Application No: AB/3/21/PD
Site Address: Riverside House 2 Fitzalan Road Arundel BN18 9JS
Description of works: Notification for Prior Approval under Schedule 2 Part 1 Class AA for erection of one and two additional storeys on existing dwellinghouse.

Thank you for your internet representation made on 9th February 2021 which has been recorded as an objection with the comments as follows:

Drawing Title:
PROPOSED ELEVATIONS

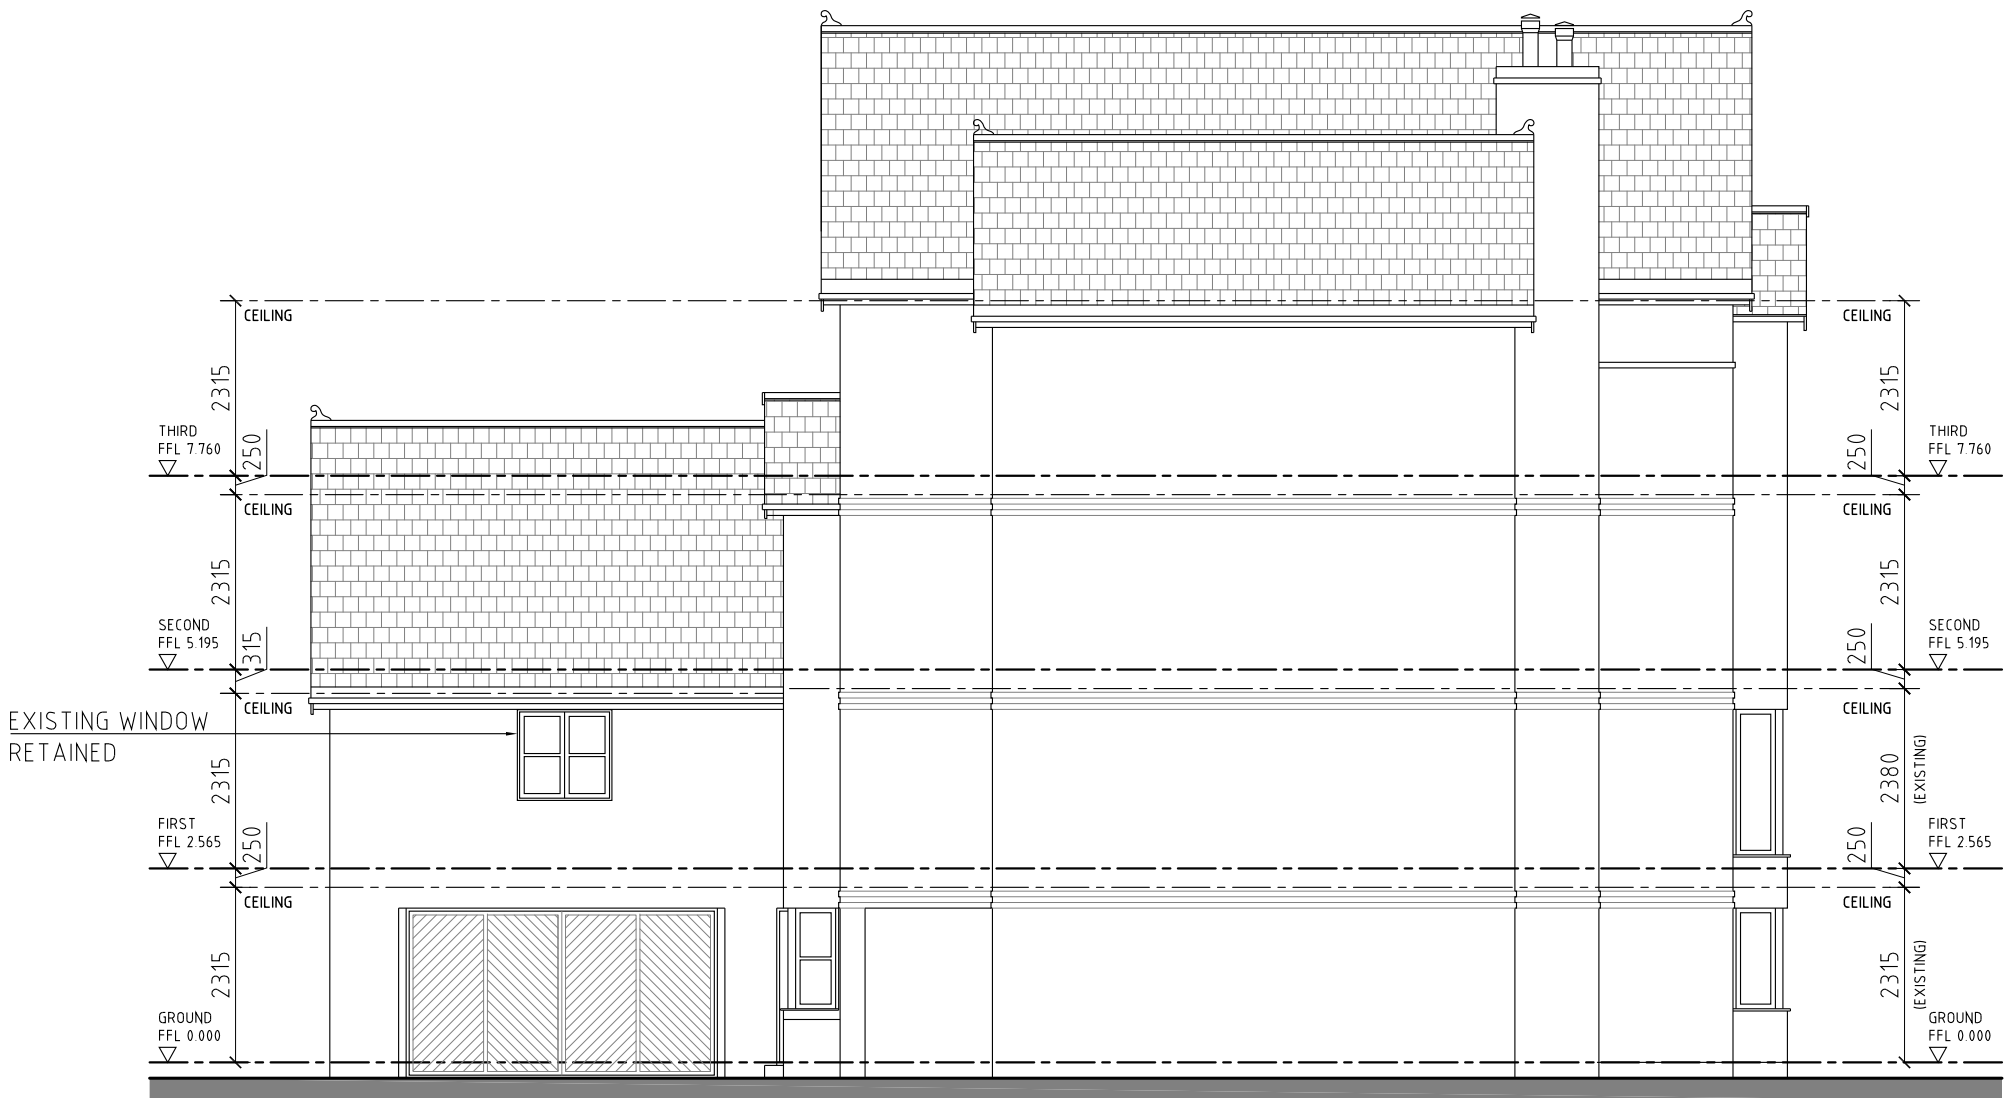
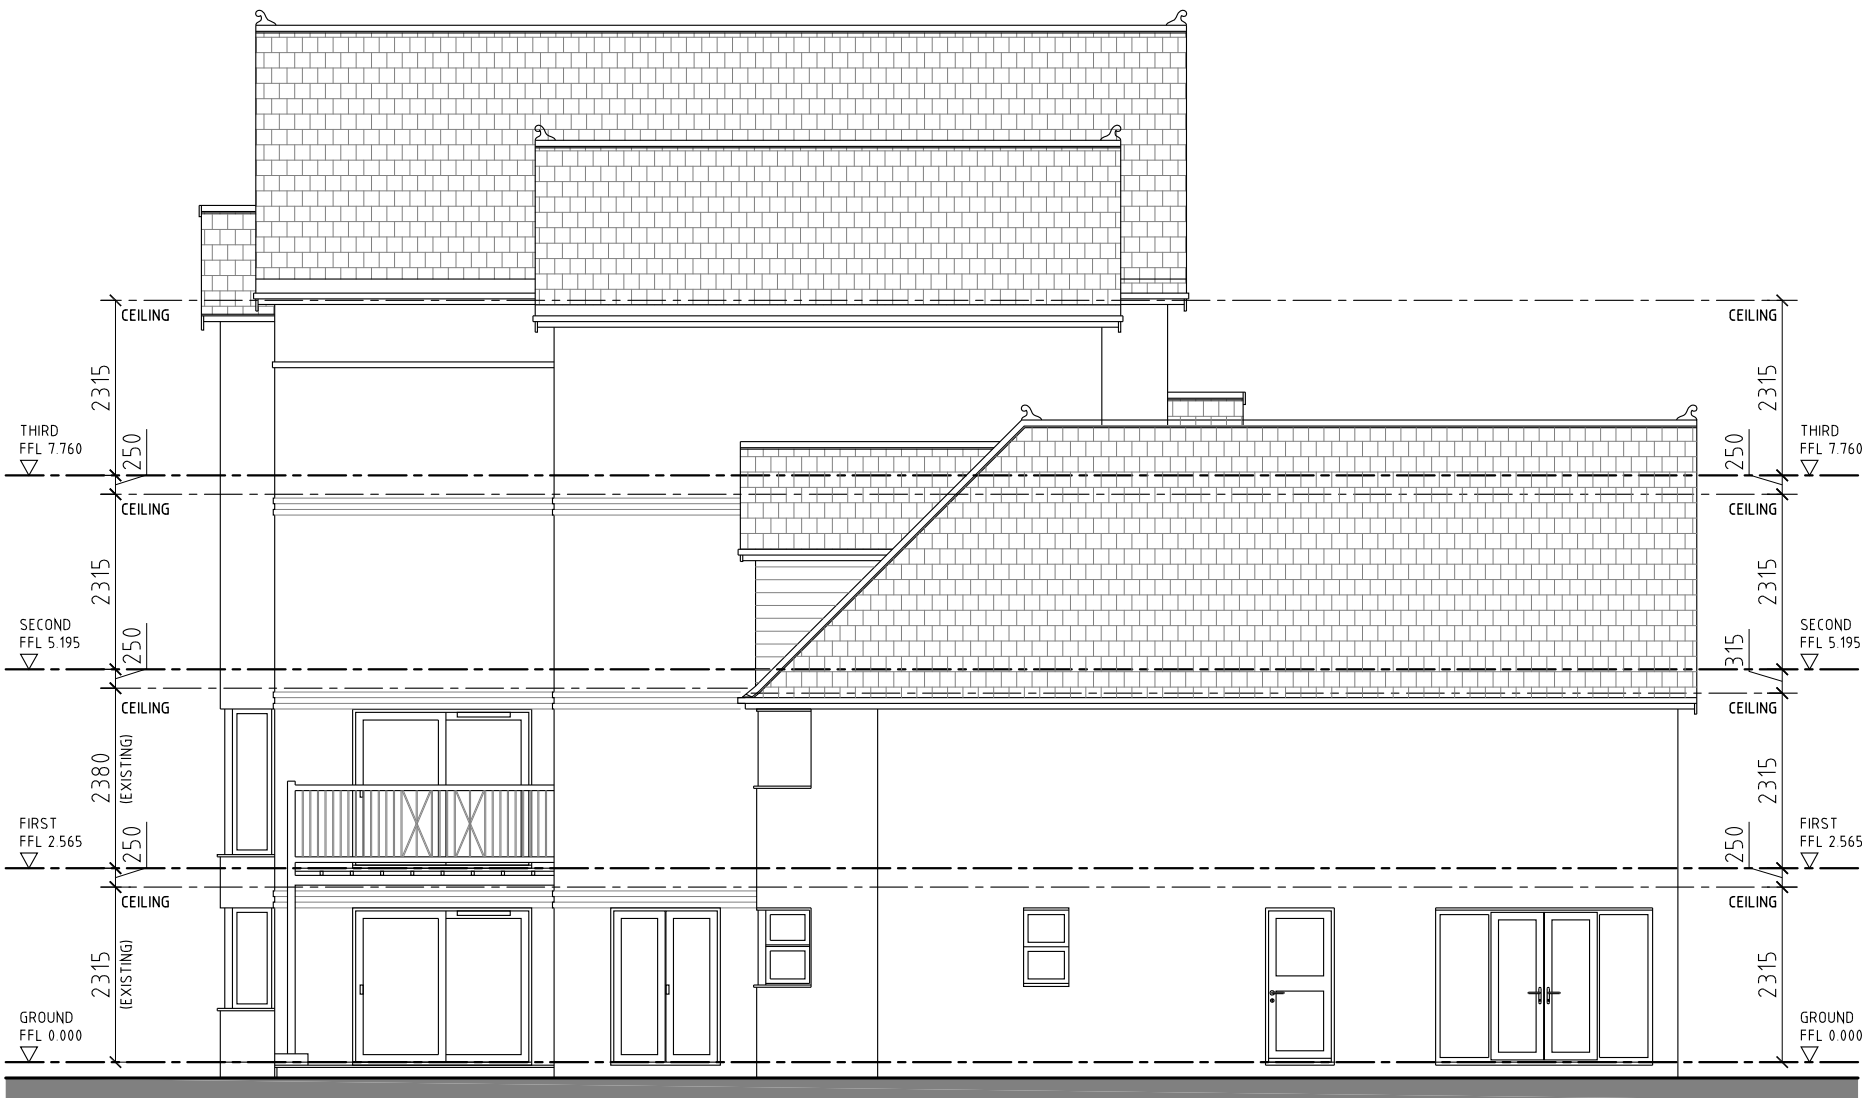
The proposed two storey extension by reason of its site coverage, bulk, height, proximity to the site boundaries and location close to the Arundel Conservation Area would result in a prominent and obtrusive dwelling which would adversely affect the visual amenities and the character of the area and would not preserve or enhance the setting of the Conservation Area. It would therefore be contrary to the policies Area2, Gen7 and Dev19 of the Arun District Local Plan and the National Planning Policy Framework
